RECOMMENDATION FOR PLANNING AND DEVELOPMENT COMMITTEE

REFUSAL

APPLICATION REF: 3/2026/0519

RETROSPECTIVE APPLICATION FOR A STANDALONE OFFICE POD FOR CAR SALES, THE USE OF FIVE EXISTING CAR PARKING SPACES AND CREATION OF AN EARTH BUND TO SCREEN THE OFFICE POD AT CLITHEROE CRICKET CLUB, CHATBURN ROAD, CLITHEROE, BB7 2AS

Title: Elevations, Plans and Cross Sections

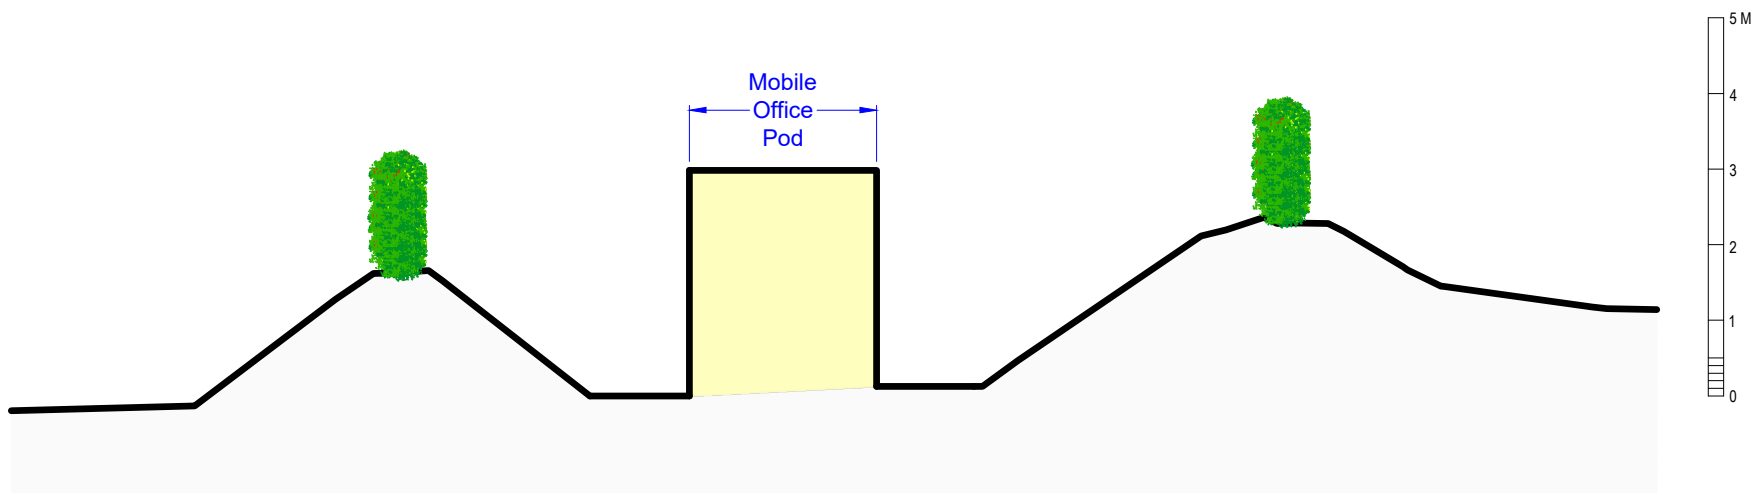
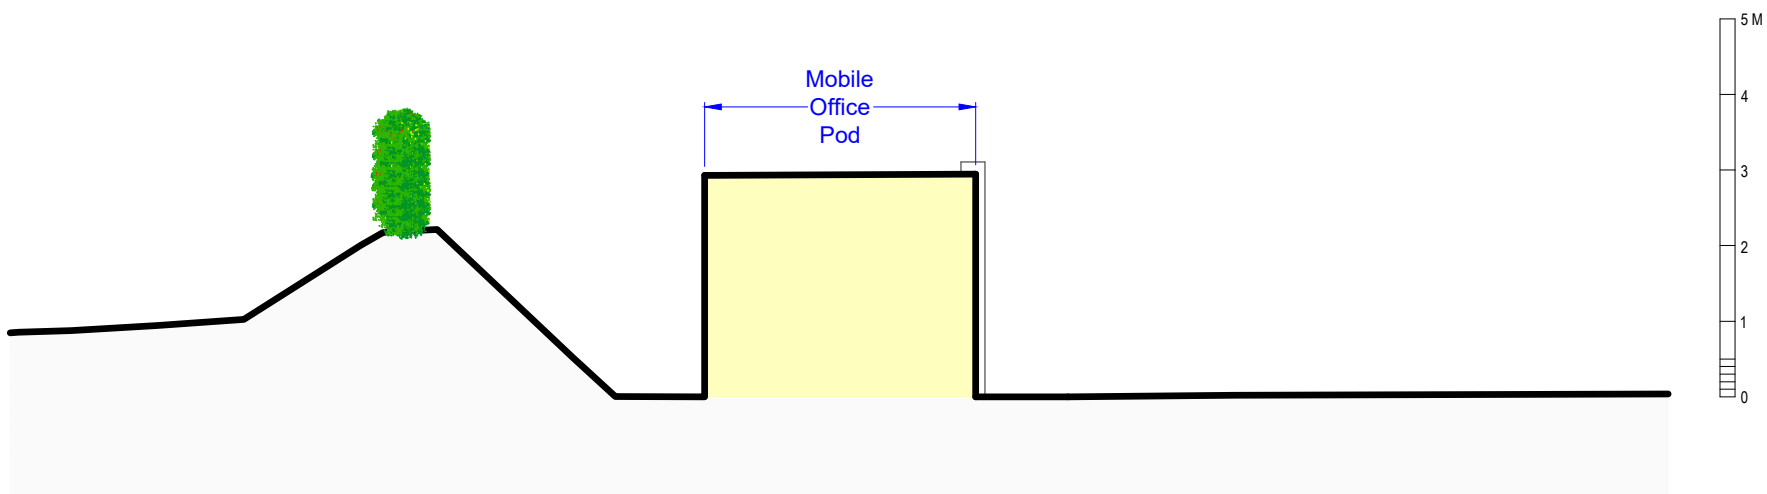
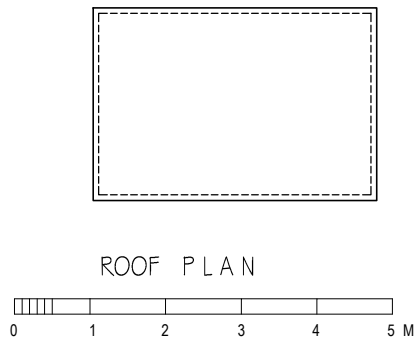
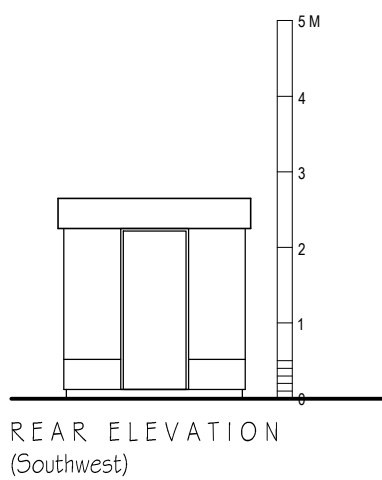
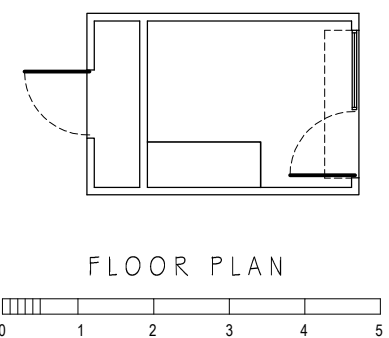
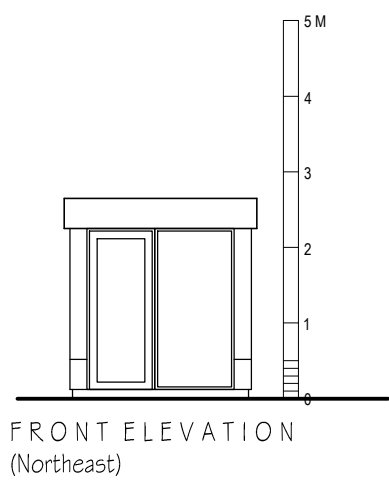
- 5.3.8 Notwithstanding this, the earth bund itself is considered to appear incongruous and anomalous within its setting. The application site forms part of an open and relatively level recreational landscape, and the introduction of a fairly significant engineered landform fails to reflect the established character or topography of the area. Whilst the bund provides a degree of screening, it also introduces a prominent and visually intrusive feature that detracts from the openness and character of the site and surrounding street scene.

- 5.3.9 Furthermore, although the bund has reduced views of the office pod when travelling along Chatburn Road from the south-west, visibility of the pod remains possible from other public vantage points, particularly when approaching the site from the north-east. From these viewpoints, the office pod remains readily identifiable as a standalone commercial structure. Its appearance, including the

5.3.10 Taken together, the office pod and the associated earth bund fail to integrate successfully with the character and appearance of the cricket ground and its surroundings. The development remains a discordant and visually prominent feature within a key frontage location and results in harm to the character and visual amenities of the area. The earth bund has not overcome the fundamental concerns previously identified in relation to the siting, design and appearance of the office pod and, in some respects, has introduced additional visual harm.

1. The proposed office pod and earth bund, by virtue of their overall siting, design and level of visual prominence, represent an incongruous, unsympathetic and visually discordant form of development that fails to respond positively to the character and appearance of the site and its surroundings. The development would result in unacceptable harm to the character and visual amenities of the area, failing to integrate successfully with its context or contribute to the creation of a well-designed place. The proposal is therefore contrary to Policy DMG1 of the Ribble Valley Core Strategy and Policies DP3 and N4 of the National Planning Policy Framework.

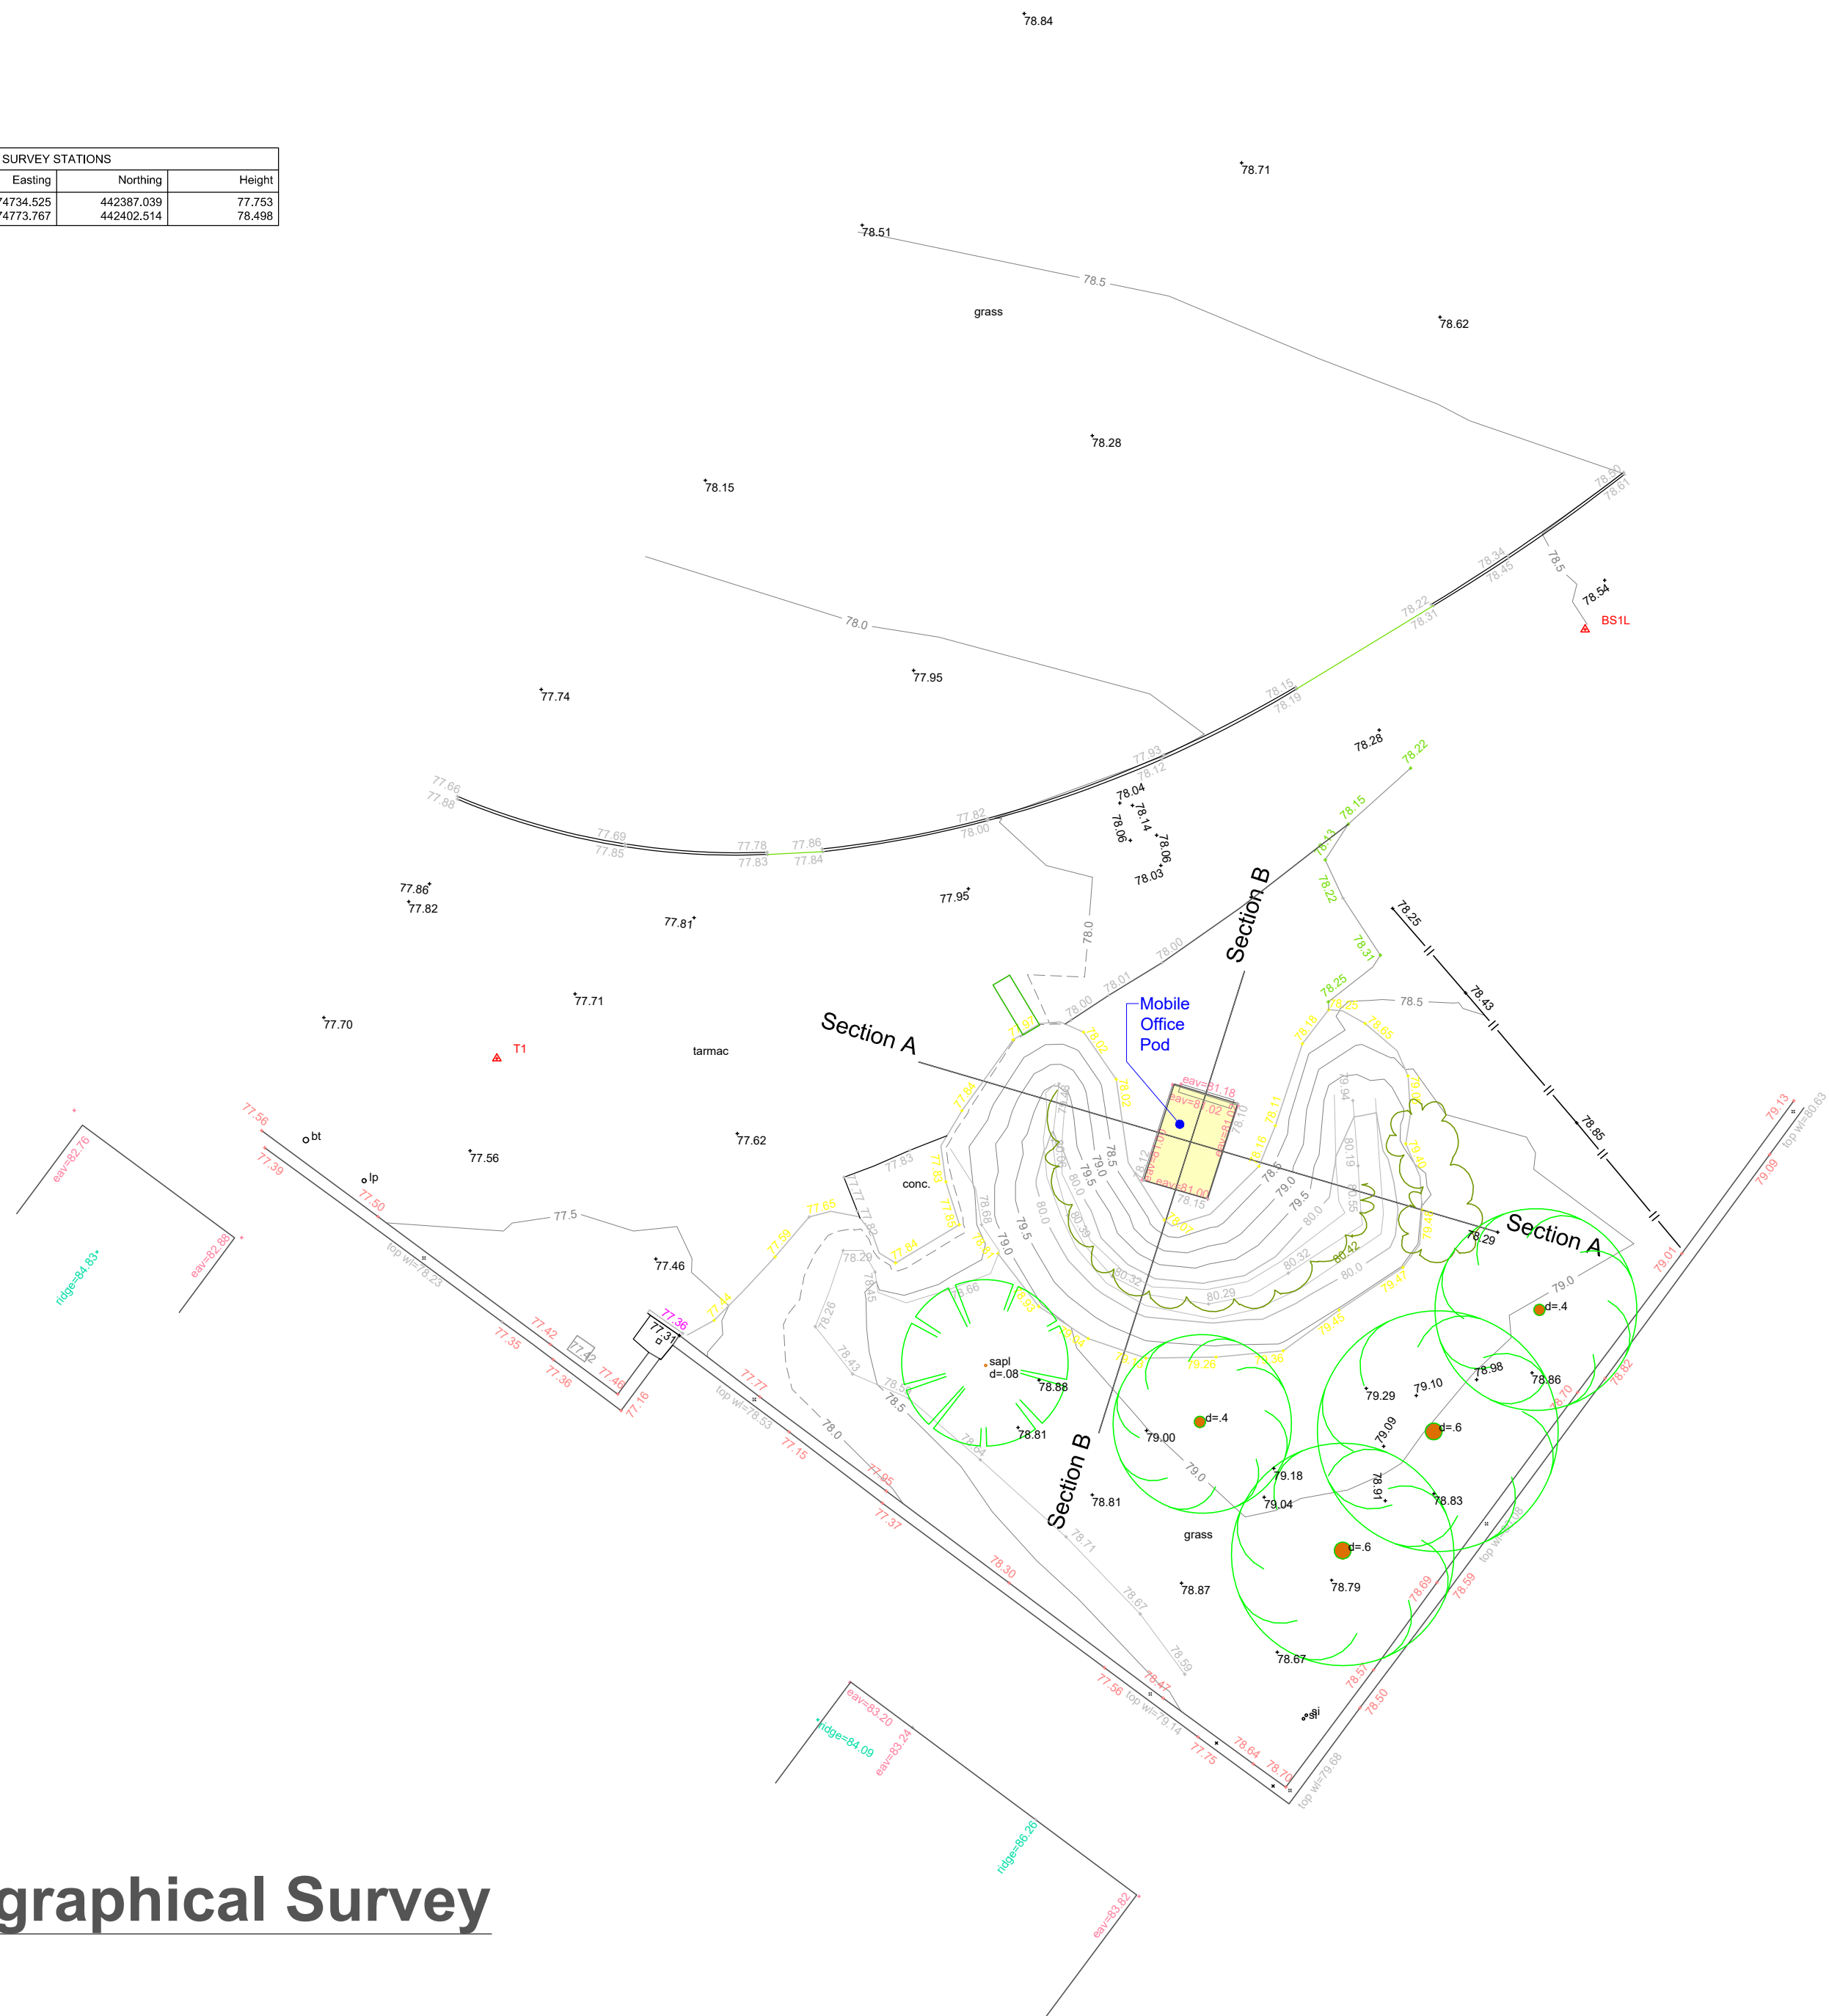
5.4.2 The application has been reviewed by the Council's Countryside Officer, who advises that all trees within the affected area have survived despite the formation of the earth bund. However, ground levels around one of the protected oak trees have been raised within its Root Protection Area, extending up to the base of the main trunk. The construction of the bund is also likely to have resulted in soil compaction, reducing soil aeration within the root zone. In order to safeguard the long-term health, stability and life expectancy of the tree, the Countryside Officer advises that ground levels around the oak should be restored to their original levels.

5.4.3 In light of the above, insufficient information has been provided to demonstrate that the development would not have an unacceptable impact on the protected oak tree. The raising of ground levels and associated soil compaction within the Root Protection Area have the potential to adversely affect the tree's long-term health and longevity.

2. Insufficient information has been provided to demonstrate that the development would not have an unacceptable impact on the protected oak tree. The raising of ground levels and associated soil compaction within the Root Protection Area have the potential to adversely affect the tree's long-term health and longevity. The proposal therefore fails to adequately address its impact on protected trees and is contrary to Policies DME1 and DME2 of the Ribble Valley Core Strategy and Policy N4 of the National Planning Policy Framework which seek to safeguard important landscape features and established trees.
